DEVIATION REQUEST (Attach diagrams, figures, and other documentation to clarify request) (Date: 12/18/2023 Initial Submittal) This deviation request is for intersection spacing and a few other geometric/roadway design elements on **Windermere Court**. As such, this deviation includes several itemized parts/elements. Please refer to deviation exhibits 1 – 6b. Deviation Exhibit 1 shows the location of this street on the site plan map.

This deviation request is for intersection spacing and a few other geometric/roadway design elements on **Windermere Court**:

LSC Responses to Deviation Redline Comments

**ACCESS CL PROFILE  
STA 1+00.00 TO 3+99.27**

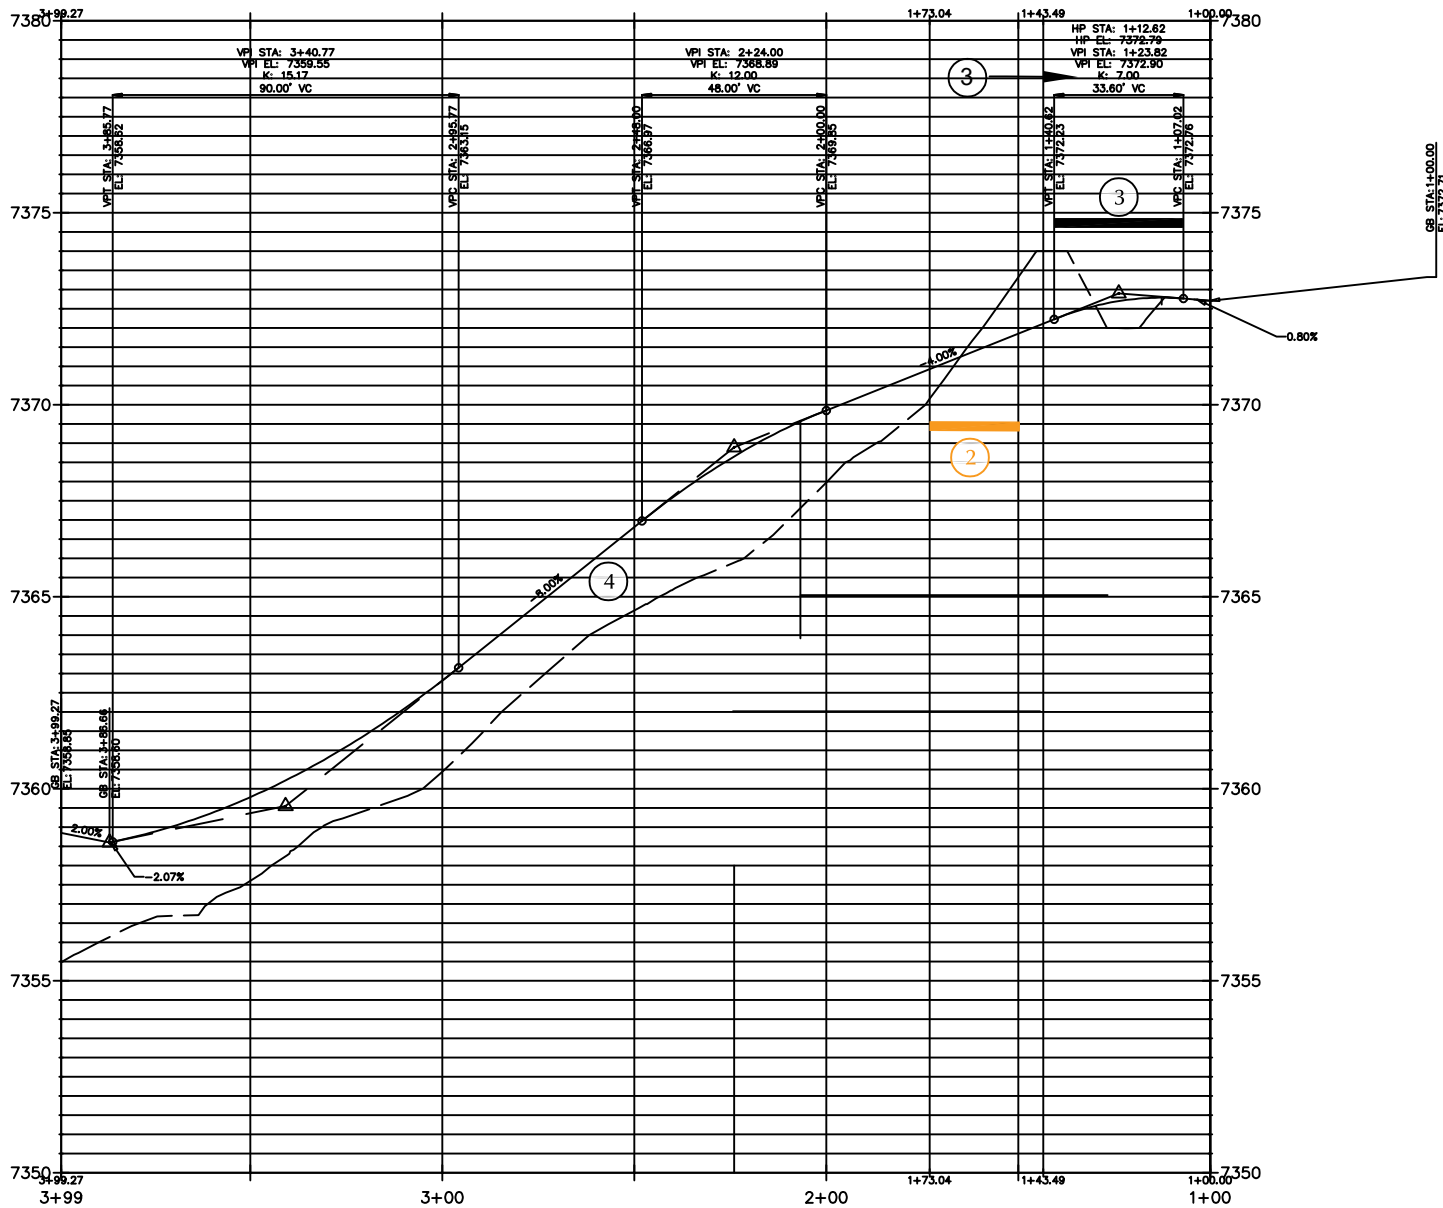
Note that the intersection grade and tangent per Tables 2.22 and Table 2.33 are not met and deviation is not recommended for the first 100ft from Winslow. Update the Deviation and road profile for Windmere Ct (name change TBD) Max 4% for first 100ft

Adjust to 4% for first 100ft per Table 2.22 and Table 2.33

Note that the intersection grade and tangent per Tables 2.22 and Table 2.33 are not met and deviation is not recommended for the first 100ft from Winslow. Update the Deviation and road profile for Windmere Ct (name change TBD) Max 4% for first 100ft

Adjust to 4% for first 100ft per Table 2.22 and Table 2.33

LSC Response: Updated as requested.

LSC Response: Updated as requested.

Deviation Exhibit 6b

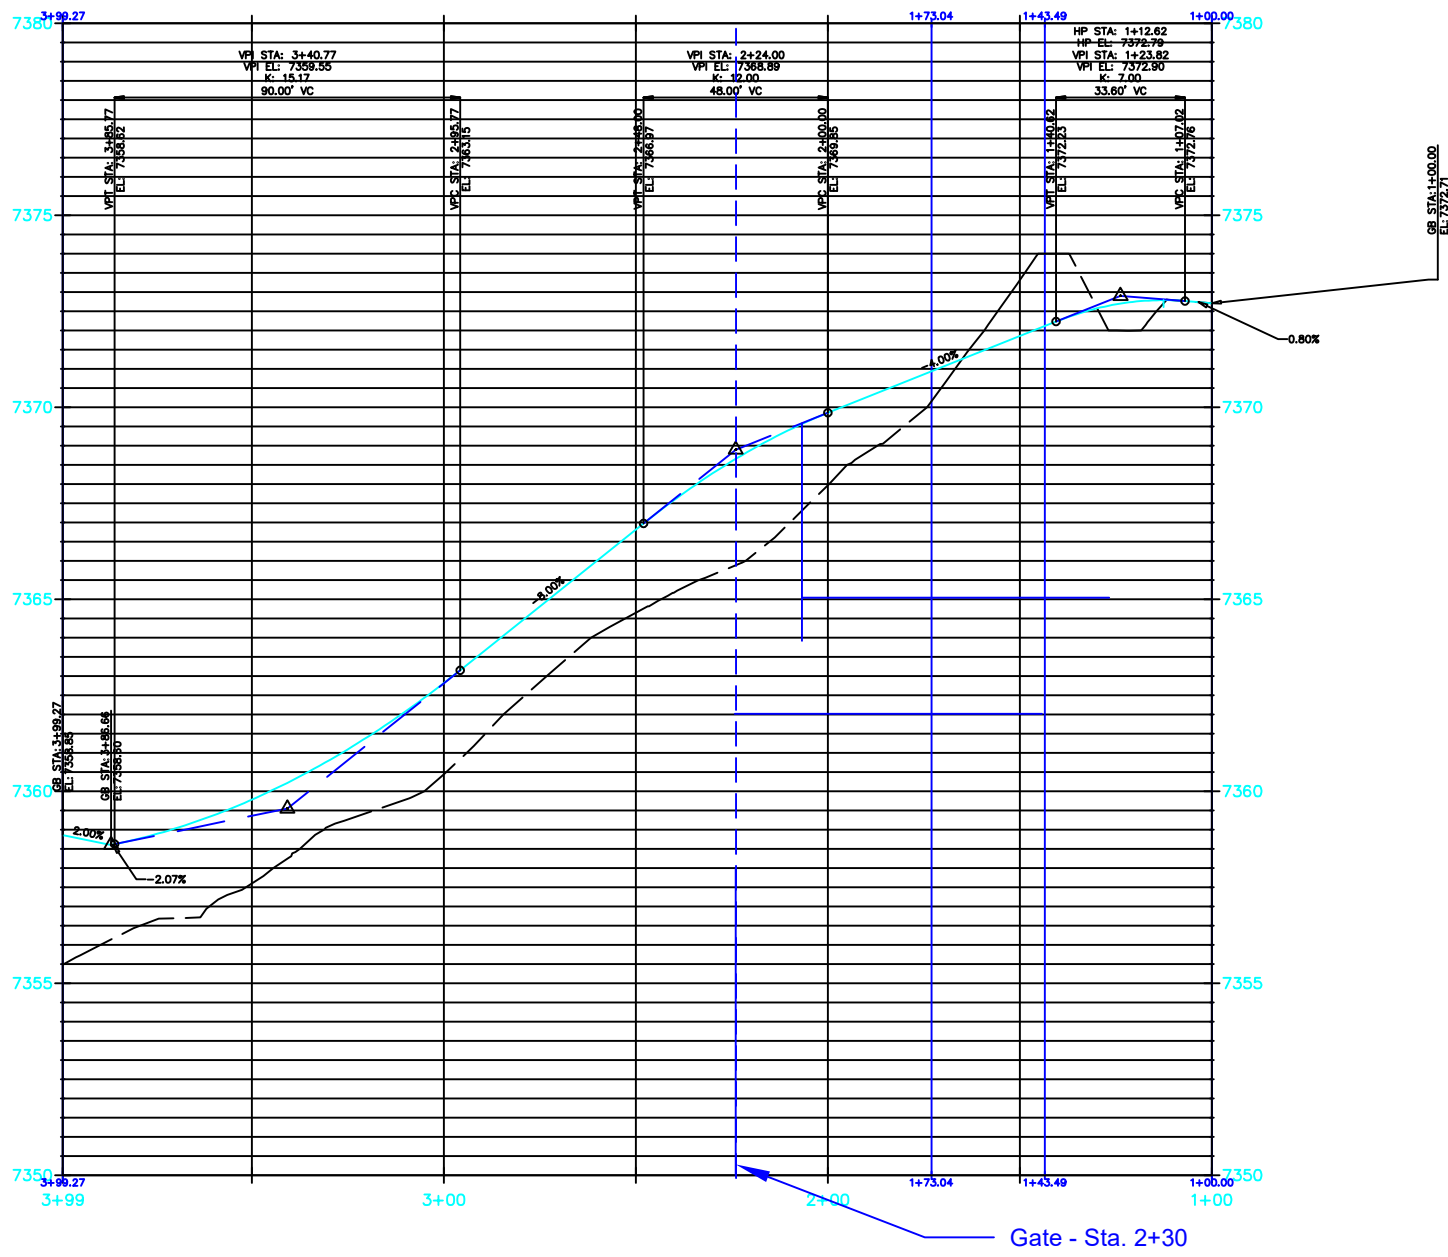
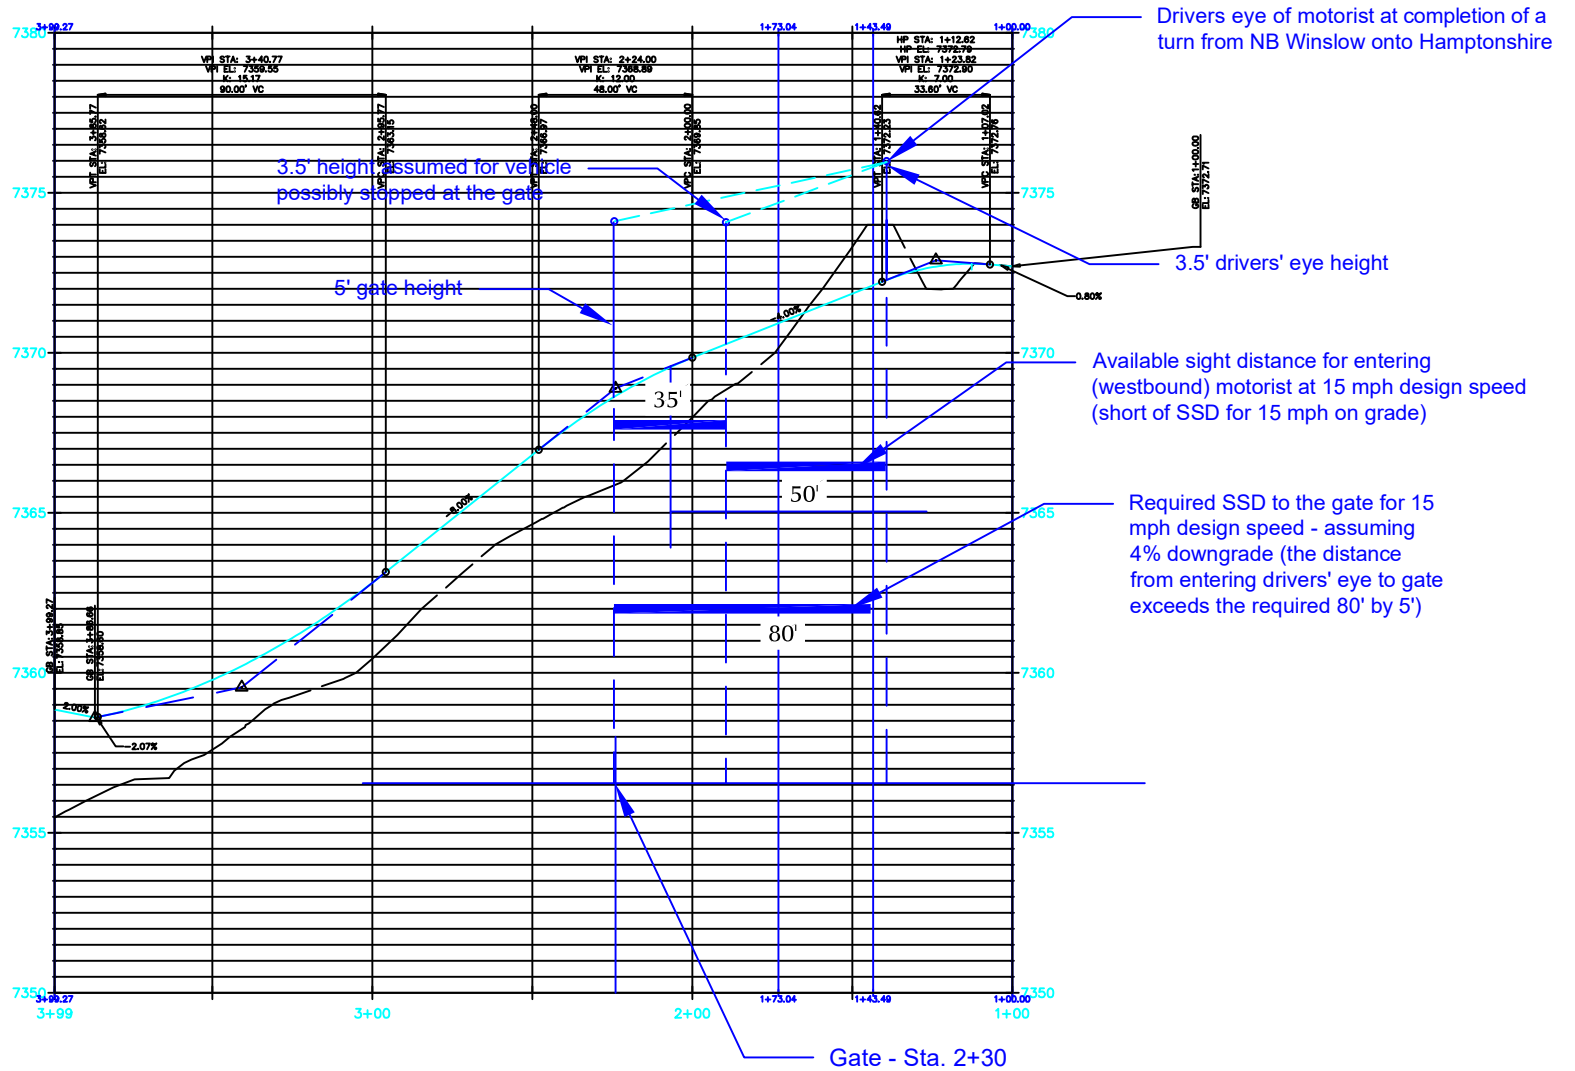
Consider low intensity lighting for gate area

It is recommended to move the mail kiosk and pull off around the corner and away from gate area

Author: Jeff Date: 3/28/2024 09:26:27
LSC Response: The applicant will consider.

LSC Response: This change has been made.
